25 Alderbrook Rd., Peaks Island - permit #2017-00257

I have completed my initial zoning review. I need the following before I can sign off:

**SITE PLAN AND  
BOUNDARY SURVEY OF LAND AT  
25 ALDERBROOK ROAD, PEAKS ISLAND  
PORTLAND, MAINE**

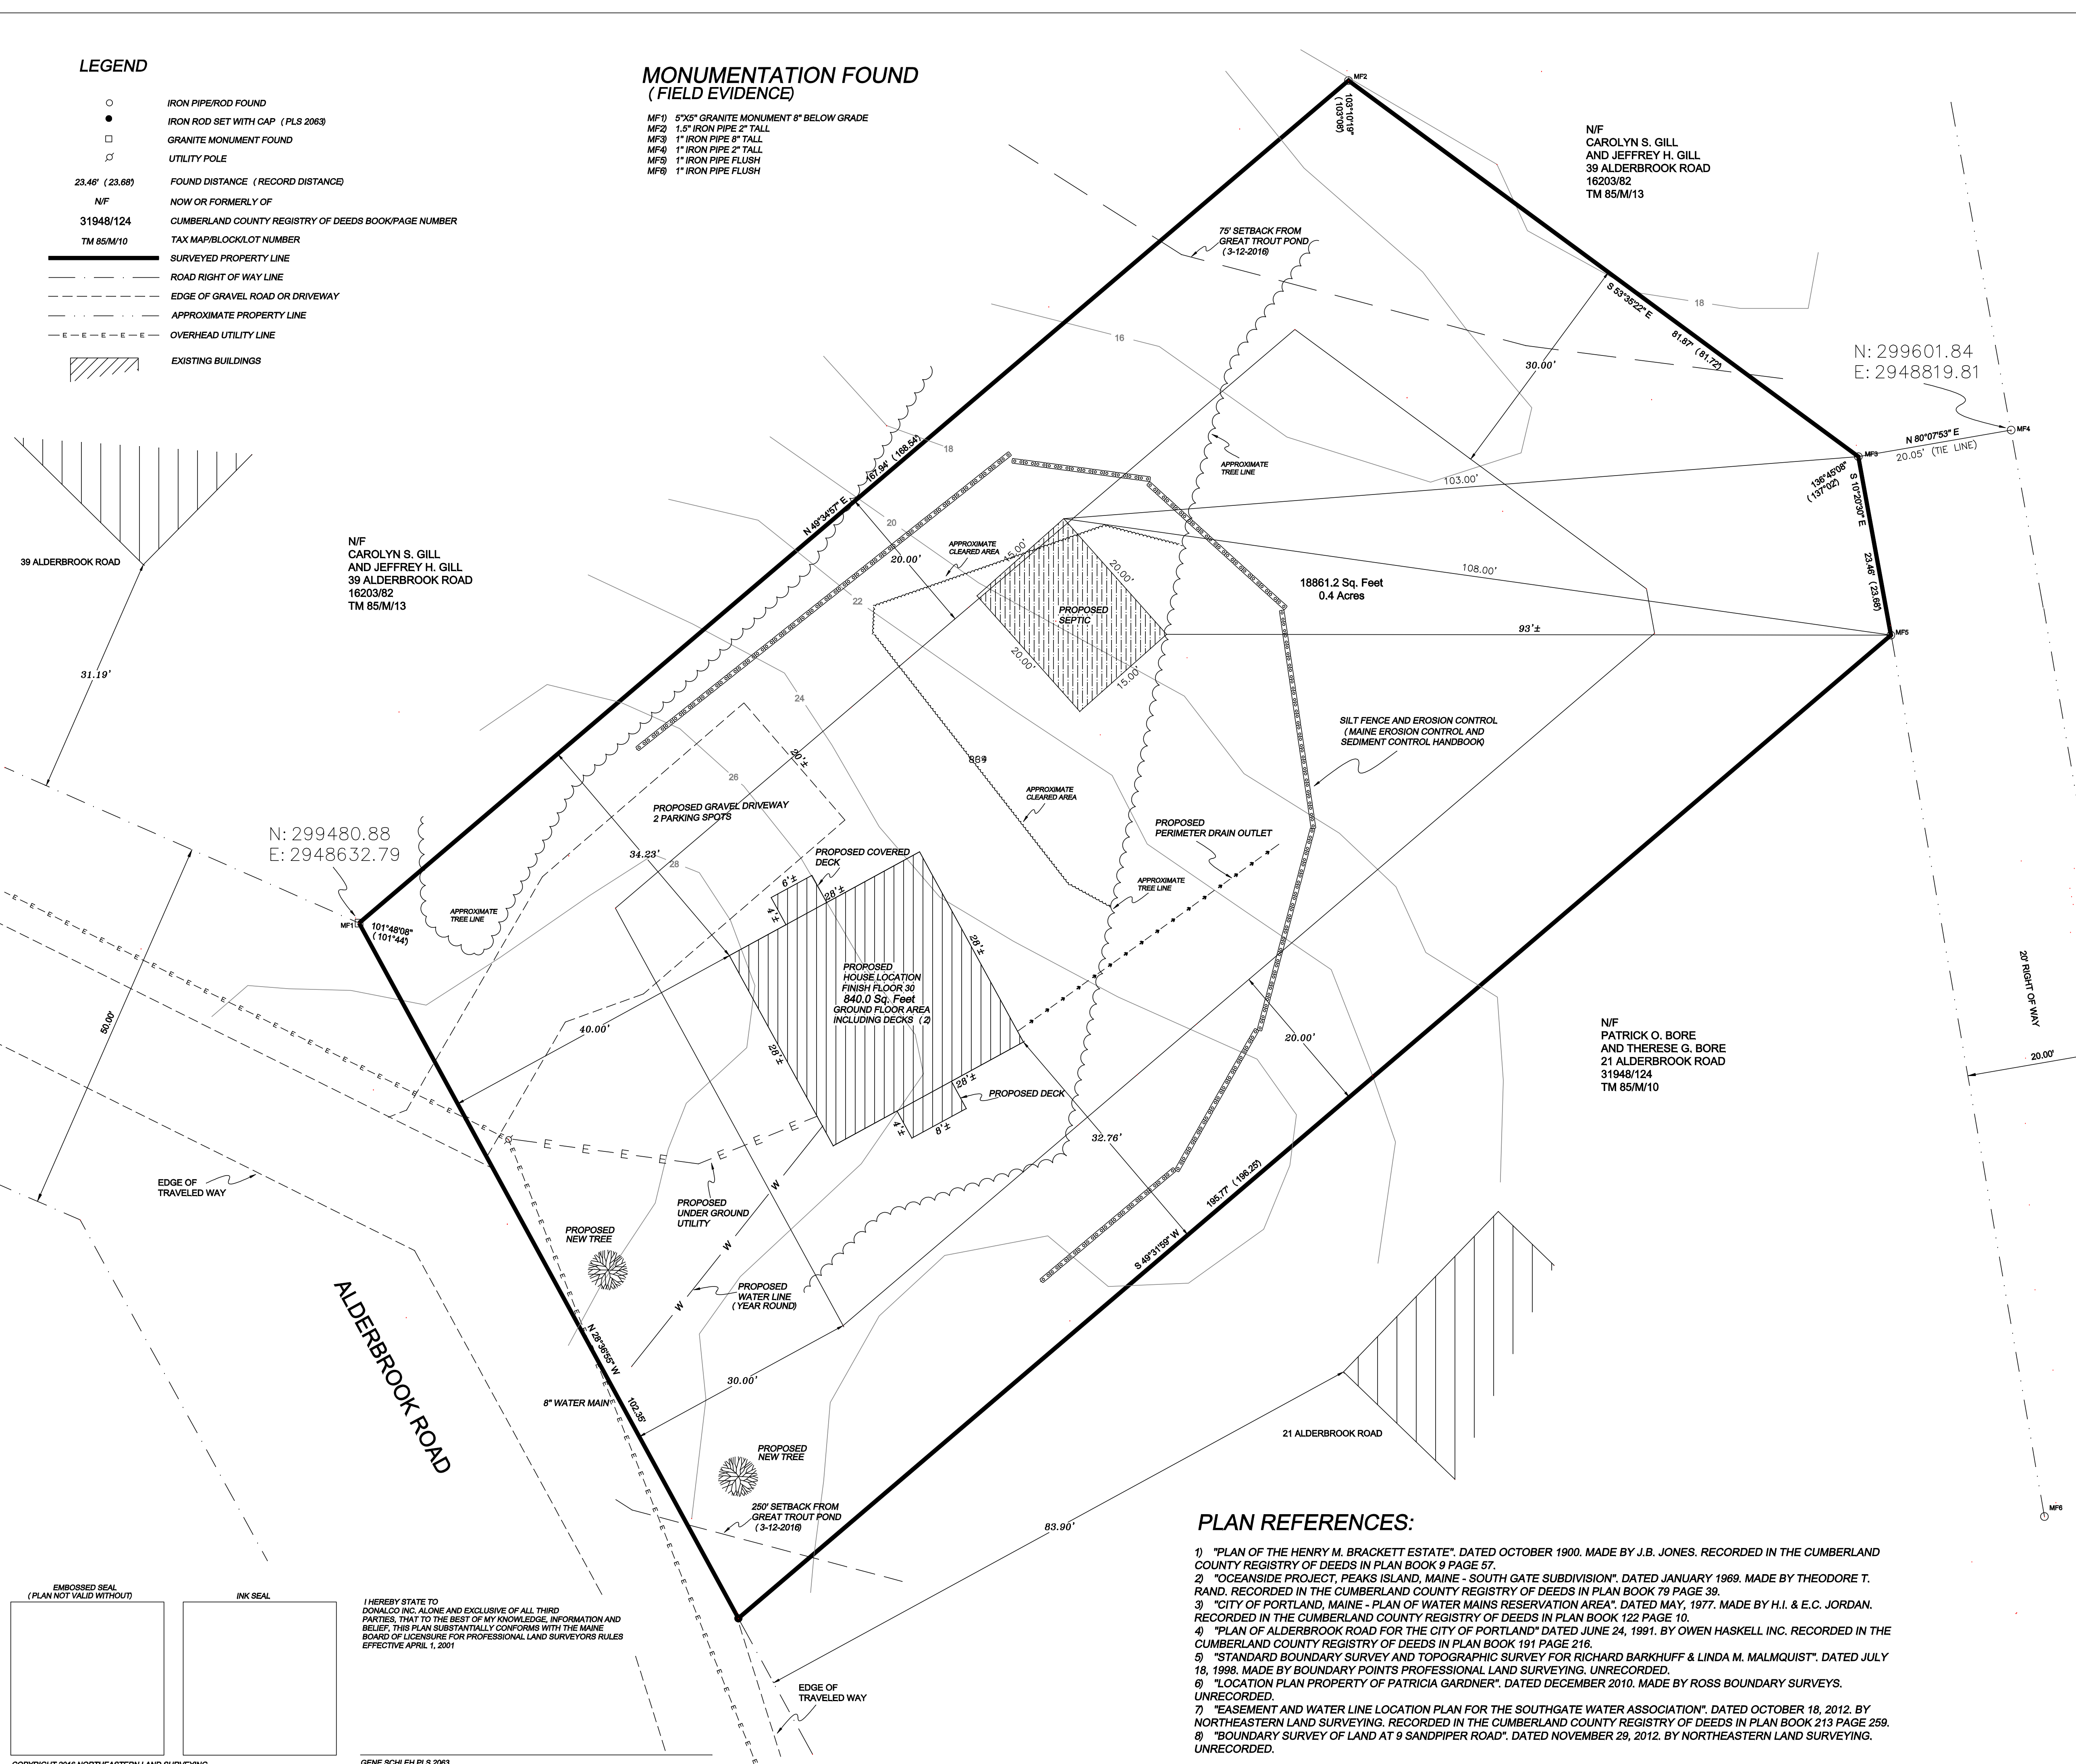
1. Copy of your current deed.
2. You need to show two parking space beyond the front yard setback of 30 feet on the site plan. The ordinance does not allow you to park in the front yard.

3. I need more information to make sure you are meeting all the Shoreland Zone requirements, particularly section 14-449(c)(4).
 - on the site plan the 75' setback should be located from the upland edge of the freshwater wetland associated with Great Trout Pond. The 250' setback from this wetland should also be shown.

- the existing cleared openings need to be shown on the site plan & the total square footage of cleared openings needs to be calculated
 - between the 75' and 250' setbacks selective cutting of 40% of volume of trees 4" or more in diameter is allowed within 10 year period - tree removal related to development is included in the 40% volume - cleared openings for development can't exceed in the aggregate more than 25% of the lot area within the shoreland zone including land previously cleared. - you need to calculate square footage of new openings for development to demonstrate that the total square footage of cleared openings does not exceed the 25%.
